# CITY OF ALBUQUERQUE

**RE: Aloft Hotel**  
**1501 Aircraft Ave. SE**  
**Conceptual Grading & Drainage Plan and Drainage Report**  
**Engineer's Stamp Date: no stamp**  
**Hydrology File: M15D057**  
**Case # HYDR-2025-00219**

Based upon the information provided in your submittal received 06/17/2025, the Grading & Drainage Plans are not approved for Demo Permit and/or Grading Permit. The following comments need to be addressed for approval of the above referenced project:

ENGINEER'S SEAL	ALOFT HOTEL ALBUQUERQUE, NM BASIN	DRAWN BY MR
		DATE 10/24/2025
RONALD R. BOHANNAN P.E. #7868	TIERRA WEST, LLC 5571 MIDWAY PARK PLACE NE ALBUQUERQUE, NEW MEXICO 87109 (505)858-3100	SHEET # 04
		JOB # 2021133

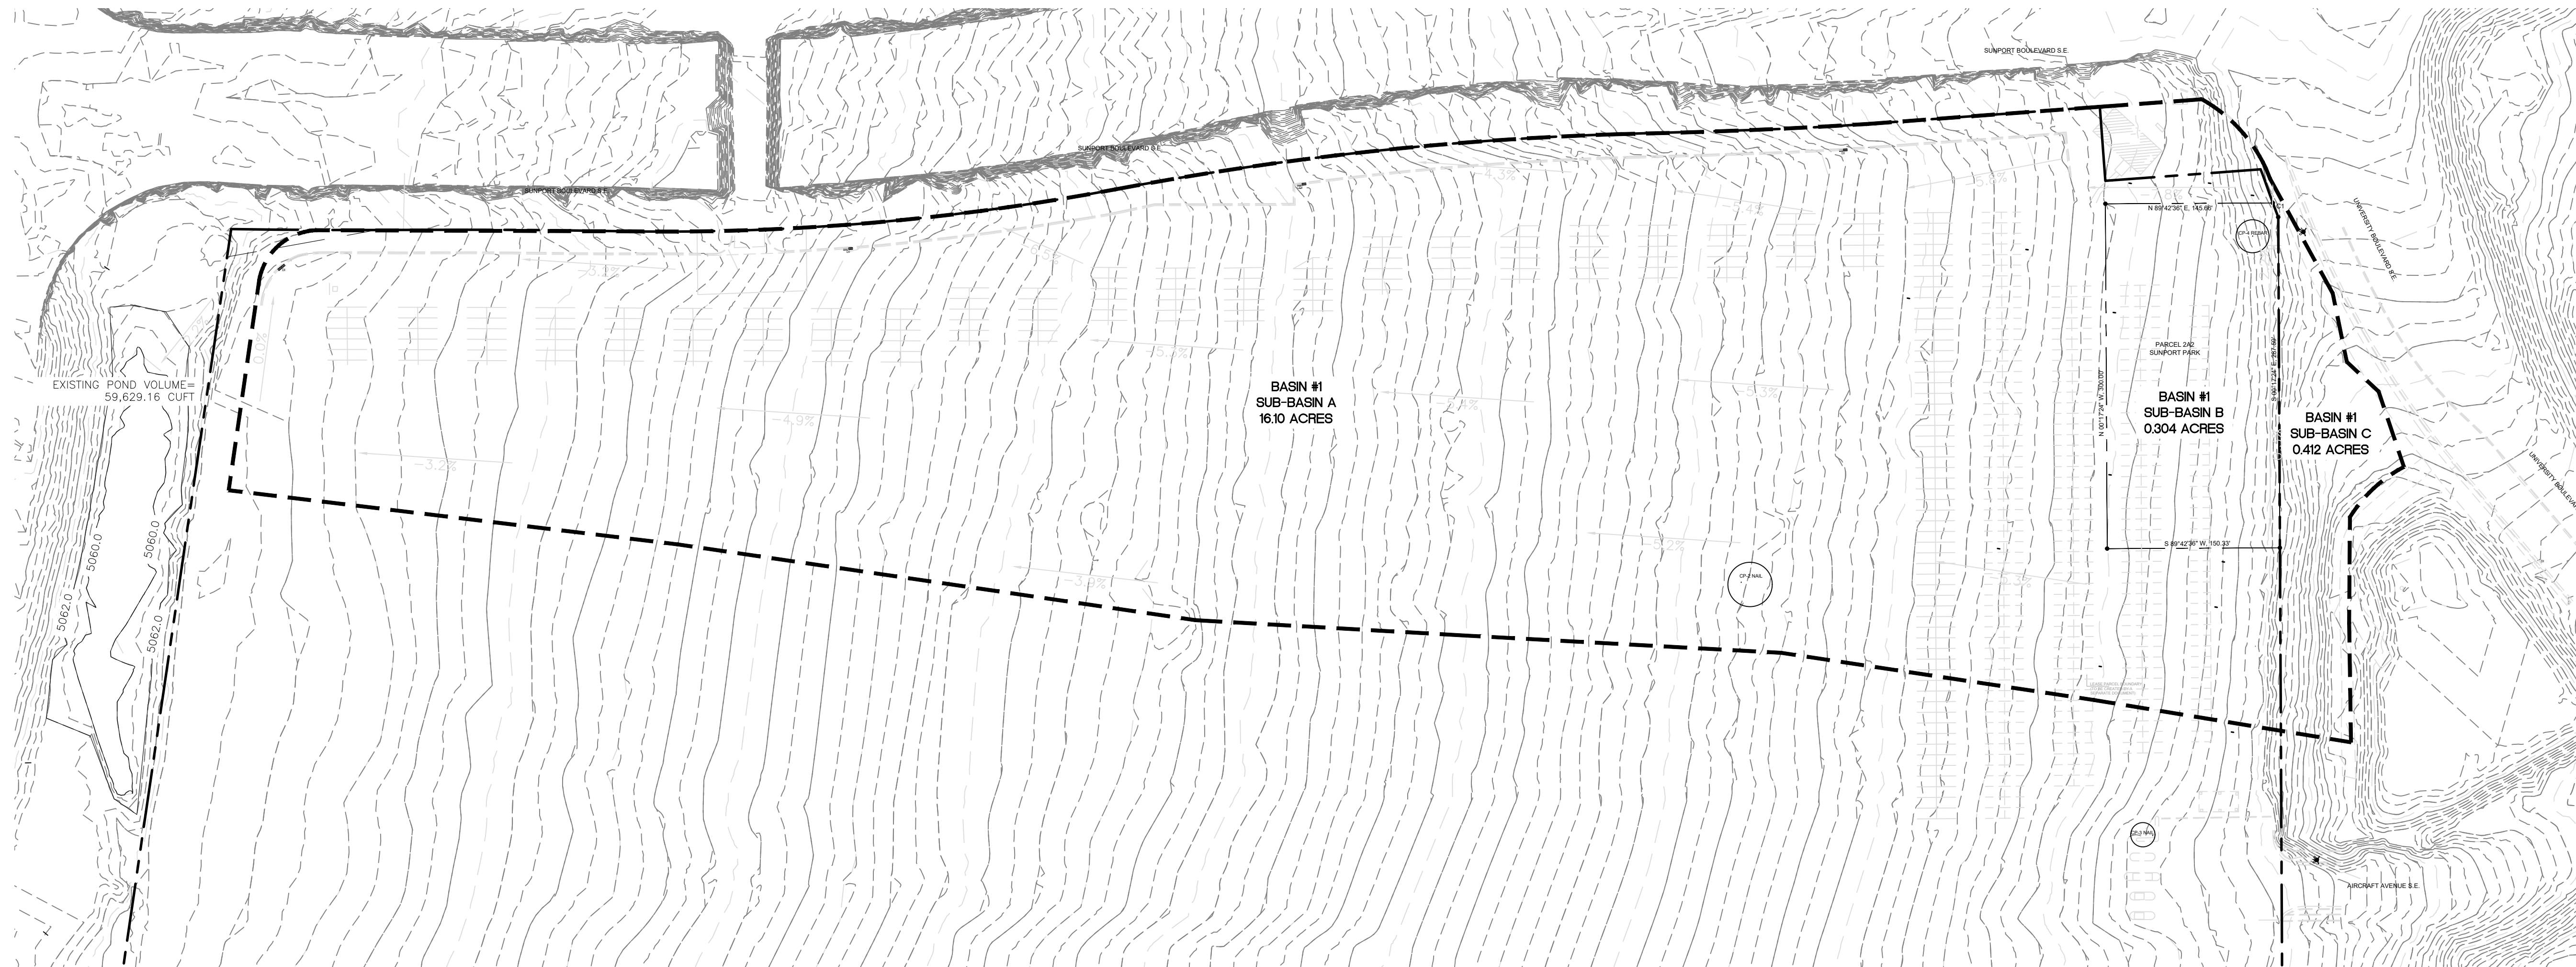
7. G&D Plans – Sheet 01 - General Notes #1 – Do the NMDOT specs need to be referenced? Should this be City Specs?
8. G&D Plans – Sheet 08 – Existing Basin Table does not match the Existing Basin Table shown on Sheet 02. Please check for consistency.
